Application Ref:	3/2025/0518	 Ribble Valley Borough Council www.ribblevalley.gov.uk
Date Inspected:	06/03/25	
Officer:	KH	
DELEGATED ITEM FILE REPORT:		REFUSAL

Development Description:	Proposed first floor extensions and alterations.
Site Address/Location:	The Bungalow, Simonstone Lane, Simonstone BB12 7NU

1 0 GROUND FLOOR
1 : 50

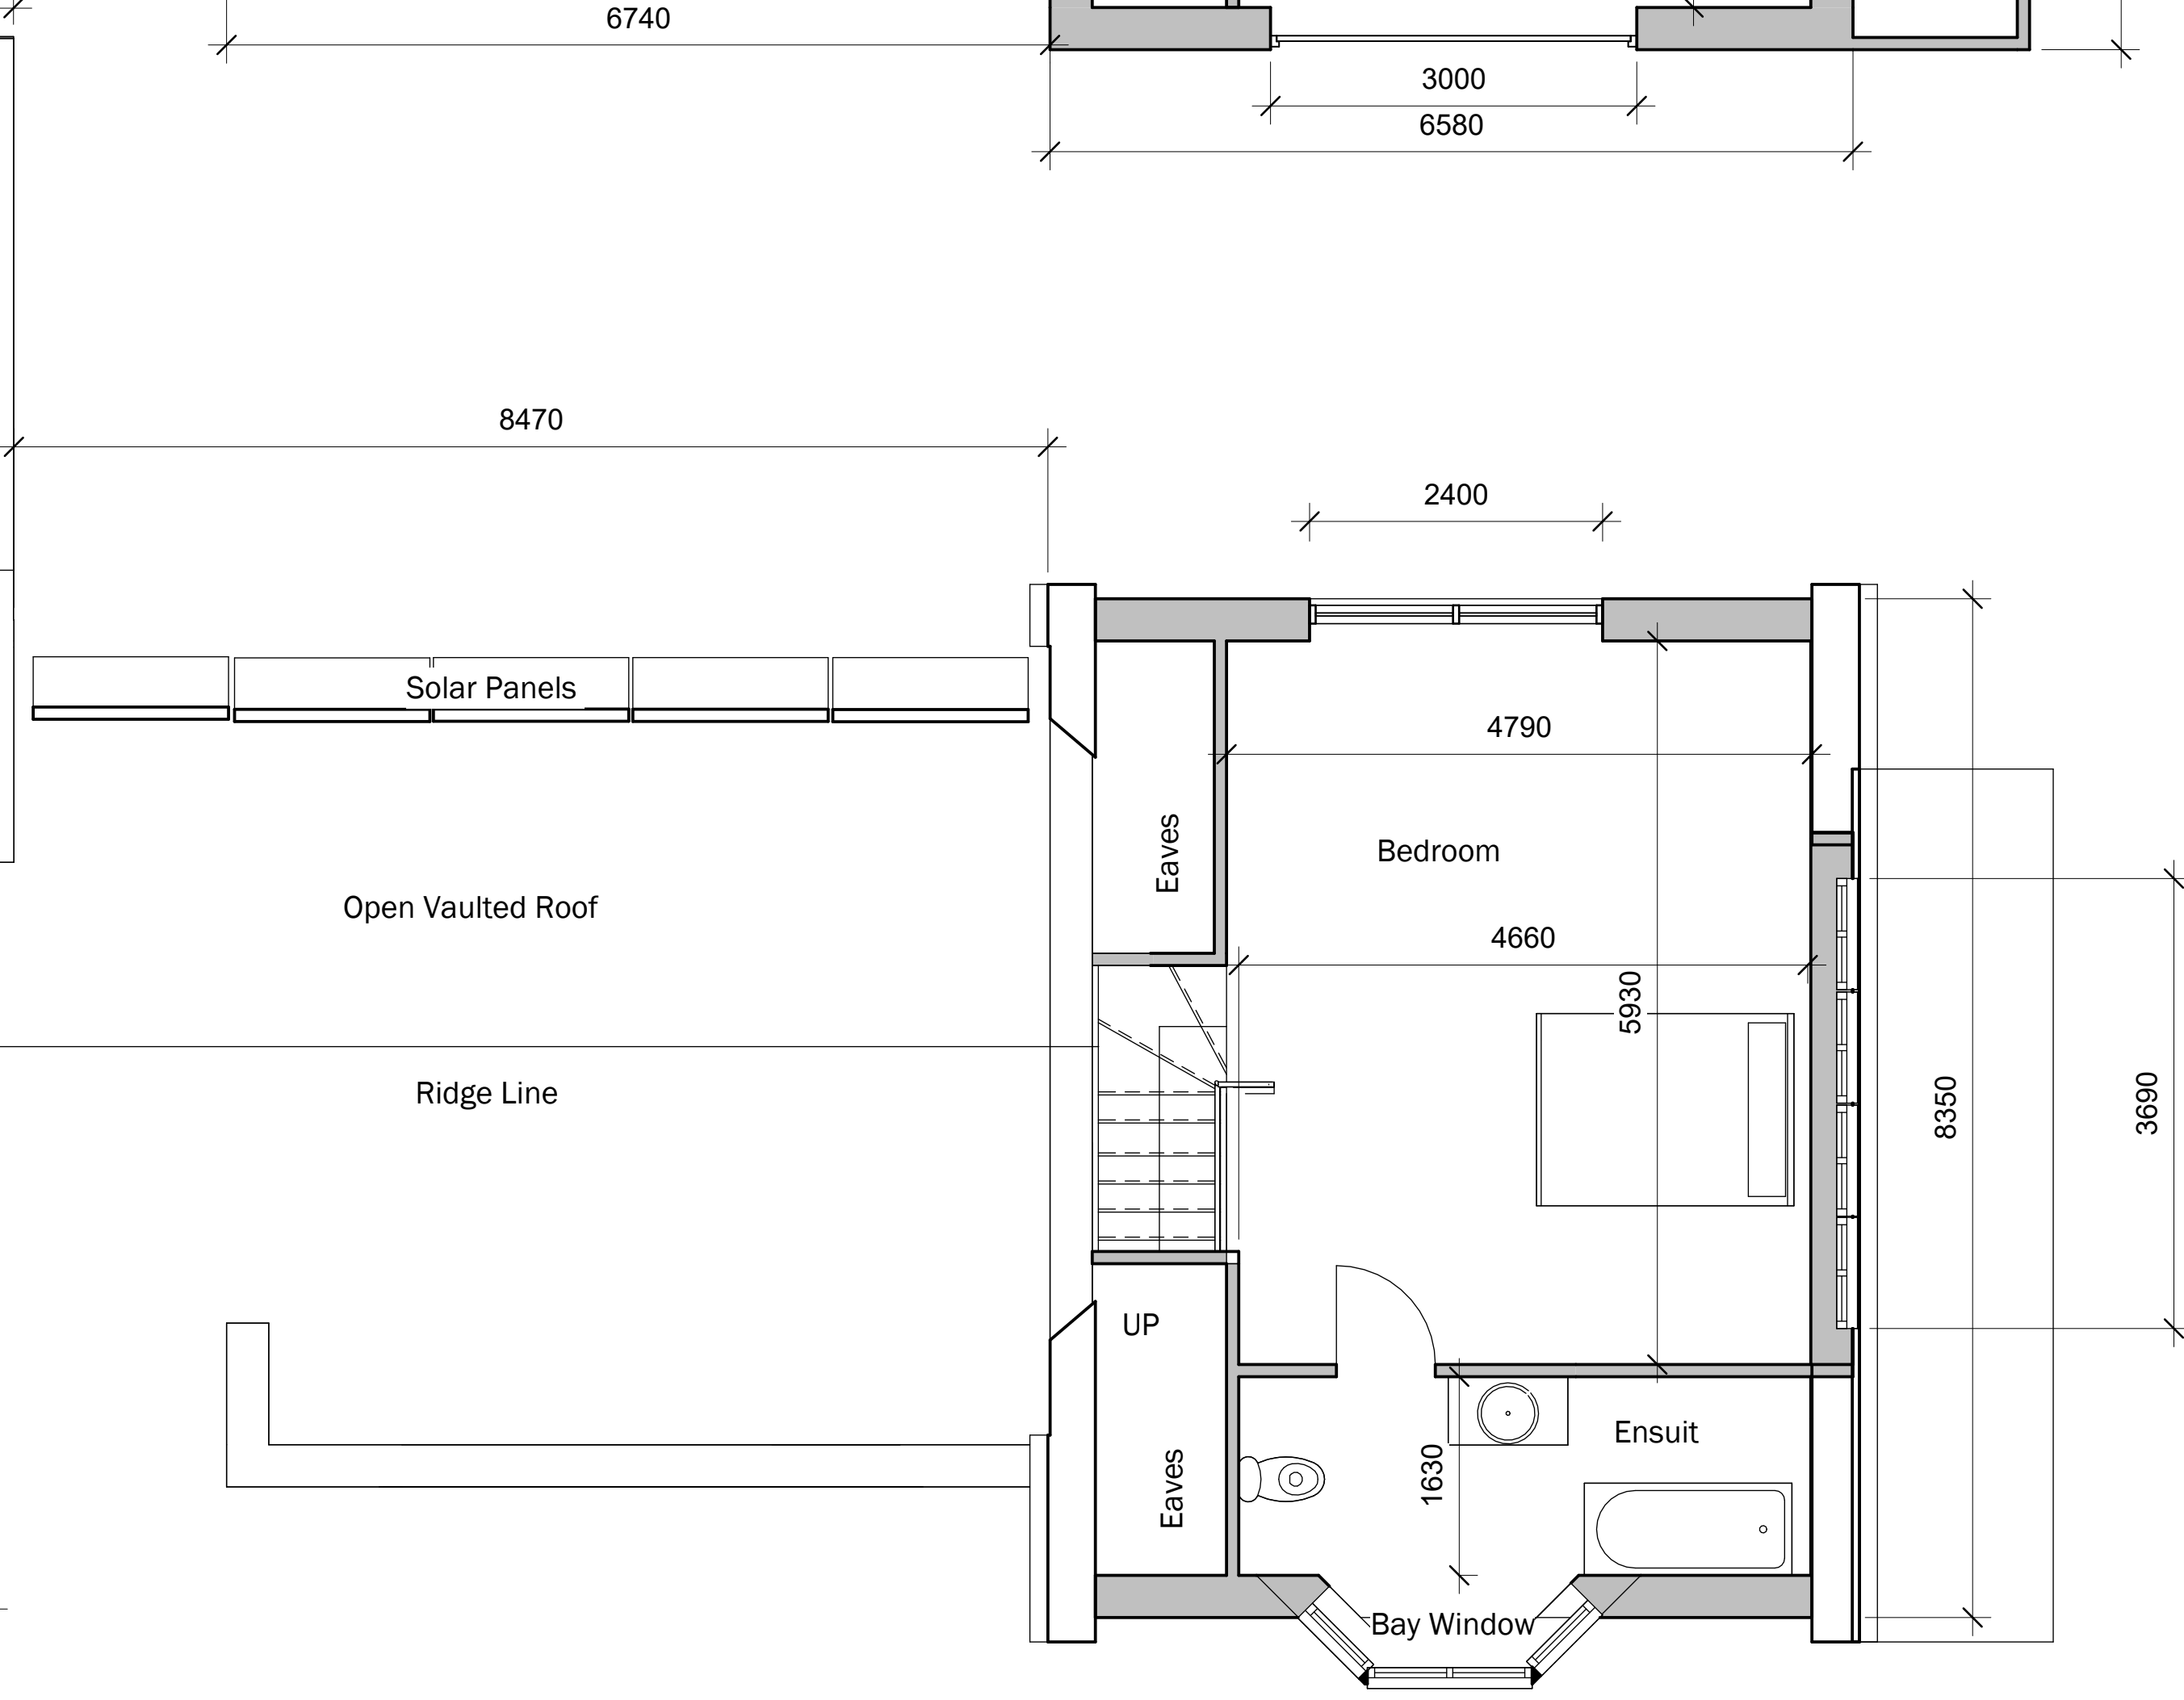
The first-floor would consist of three elements measuring approximately 9m x 10.5m, 9m x 8.5m and 8.3m x 7.6m with an overall height of 7.36m (eaves height of 2.45m) constructed with a slate roof and will form a bedroom, dressing room, ensuite bathroom, balcony and office space to the western end and an ensuite bedroom to the eastern side of the newly formed roof space with a central void area.

First floor bay windows are proposed as well as solar panels to the southern roofslope.
